Berkshire, Buckinghamshire &
Oxfordshire Wildlife Trust
The Lodge, 1 Armstrong Road,
Littlemore, Oxford, OX4 4XT
Tel: 01865 775476
Email: info@bbowt.org.uk
Visit: bbowt.org.uk

BBOWT response to planning application reference 23/02098/OUT for the Begbroke Innovation District ('the Site')

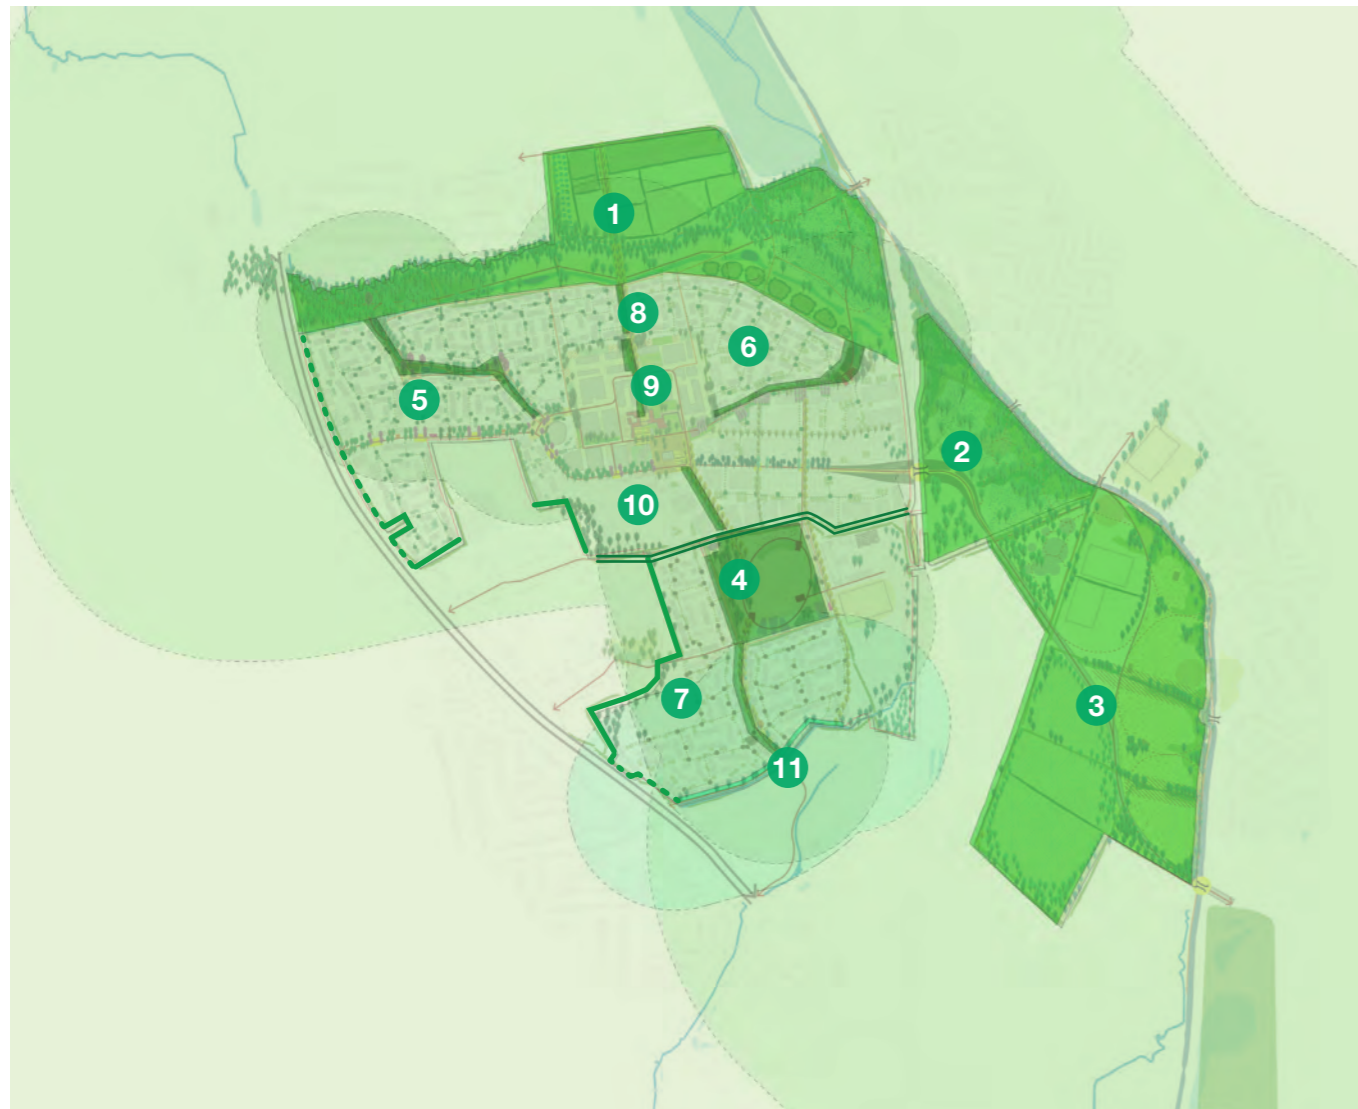
Even if the allotments and orchards can be argued to fit the description of an LNR then at least the buildings and roads or paved paths (as shown in the illustration for Rowel Brook Park North in part 7 of the D&A) should not be included in the 29.2ha of LNR.

Policy PR8 – Policies Map – Land East of the A44

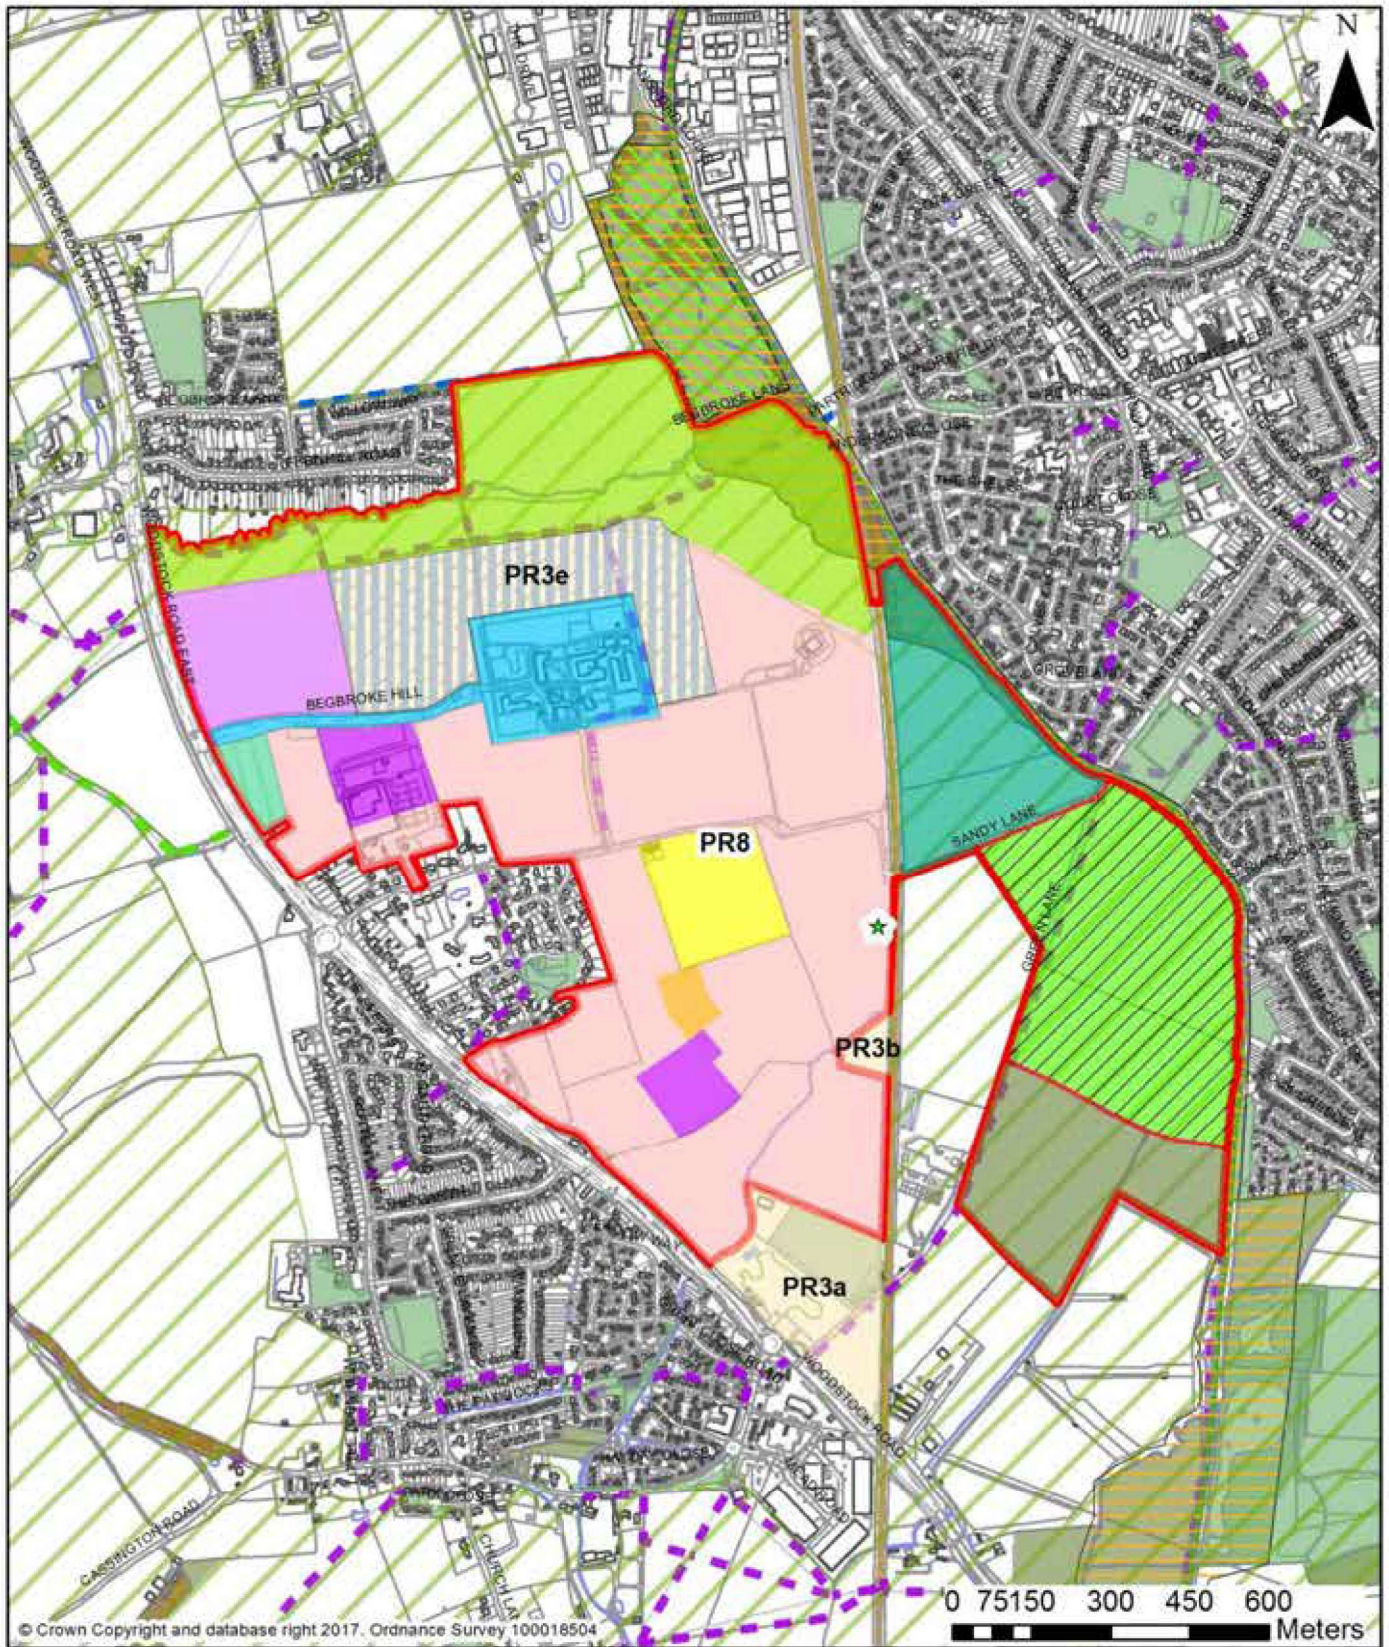
The map **Policy PR8 Policies Map – Land East of the A44** is very specific about the location of the proposed LNR and making up the 29.2 ha using another area of the site would not fulfil one of the key roles of placing a 29.2 ha Local Nature Reserve (LNR) in the north part of the development as very clearly set out in the Local Plan Partial Review, which is to create natural habitat, managed as a nature reserve, in the areas close to the SSSI. Such measures, effectively expanding the area of the SSSI habitats, are essential to make the SSSI more resilient to impact and thus mitigate for what would otherwise be a development that would create unacceptable risk of impact on SSSI.
